Avondale Drive Estate

RMA Post-Submission Update

Project	Origin	Zone	Level	Type	Role	Number
AVD - PRP - 02 -			02 - GA -		A -	20801
Revision	Status					
STAGE ISSUE	S4 - PLANNING

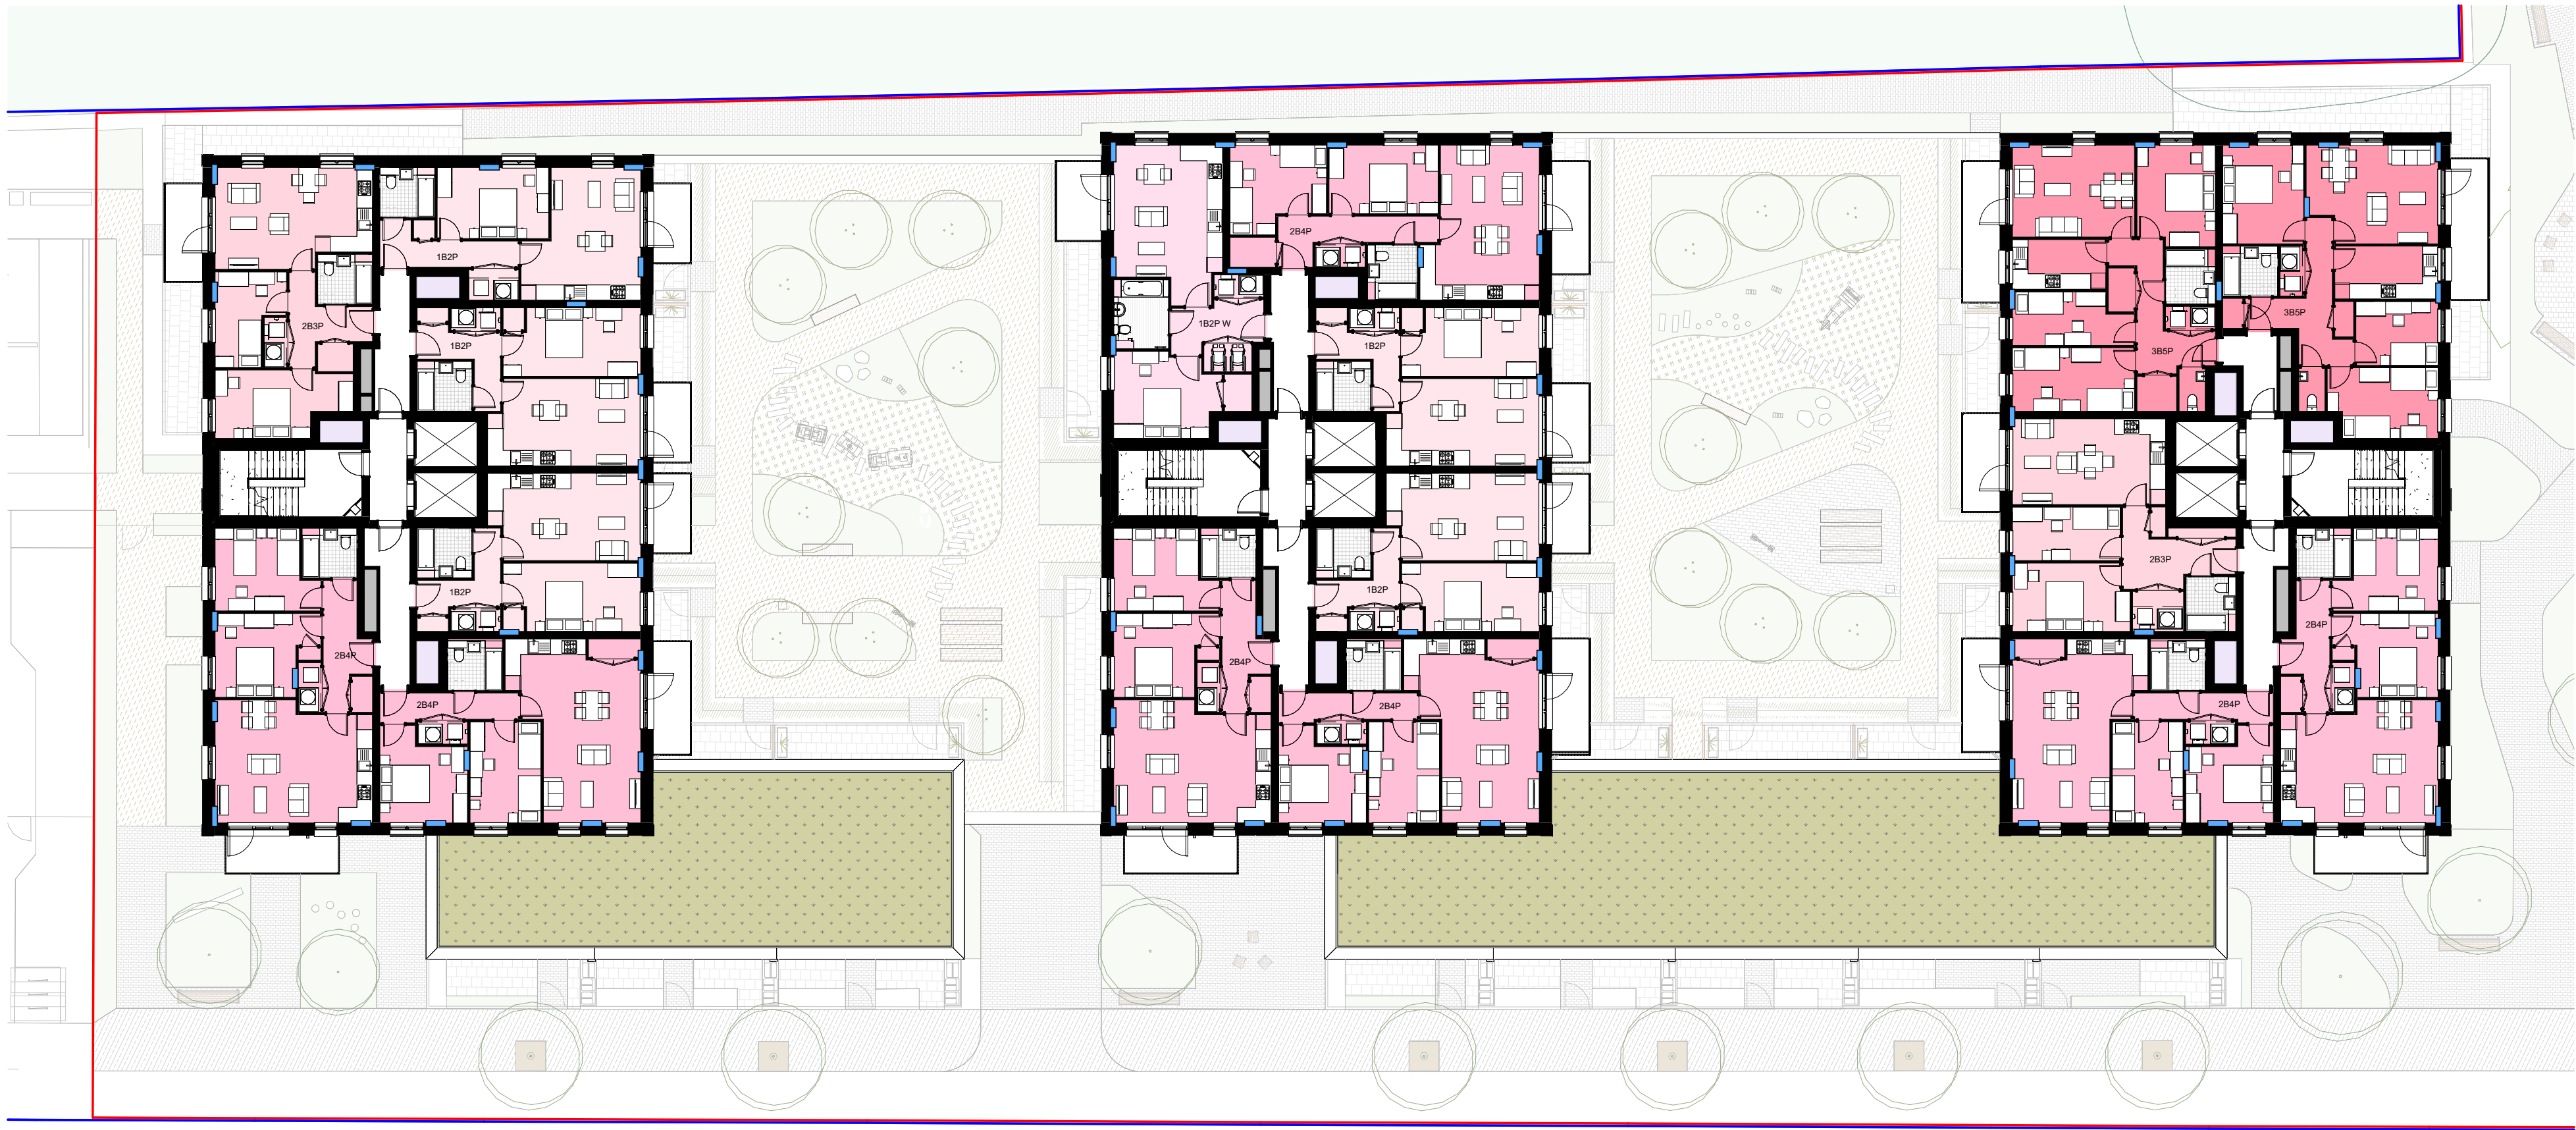
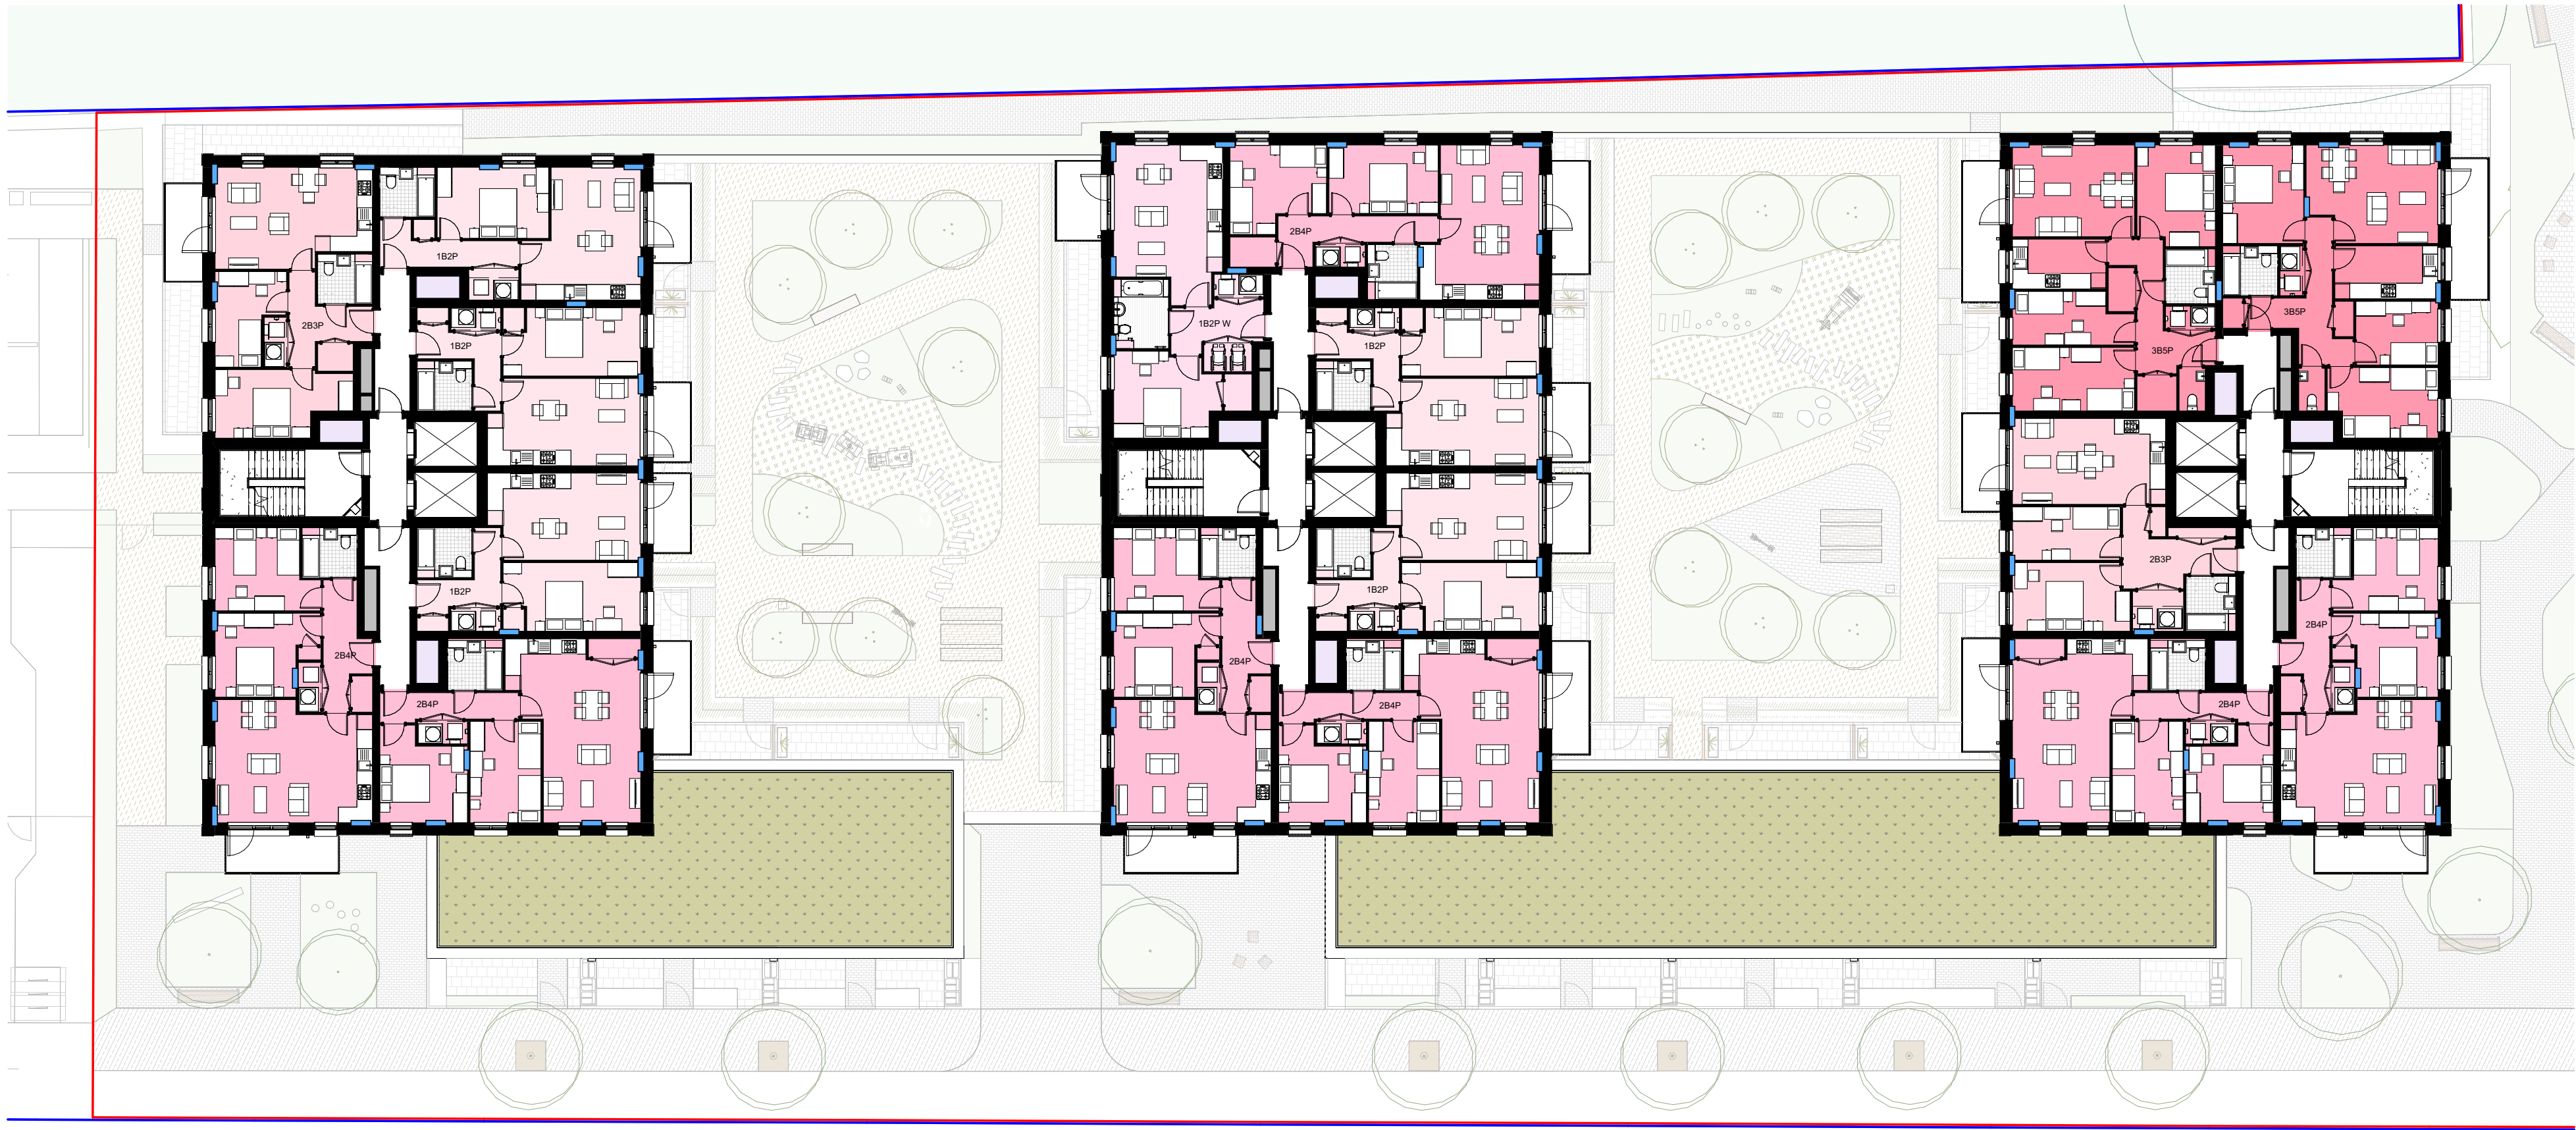
- addition of window to corner unit 2
- adjusting balcony to work with new window arrangement (unit 2)
- swapping bedroom placement with kitchen to have better relationship between living room and kitchen (unit 1)
- relocating single bedroom (unit 2)
- joining kitchen with living room to create open plan (unit 2)
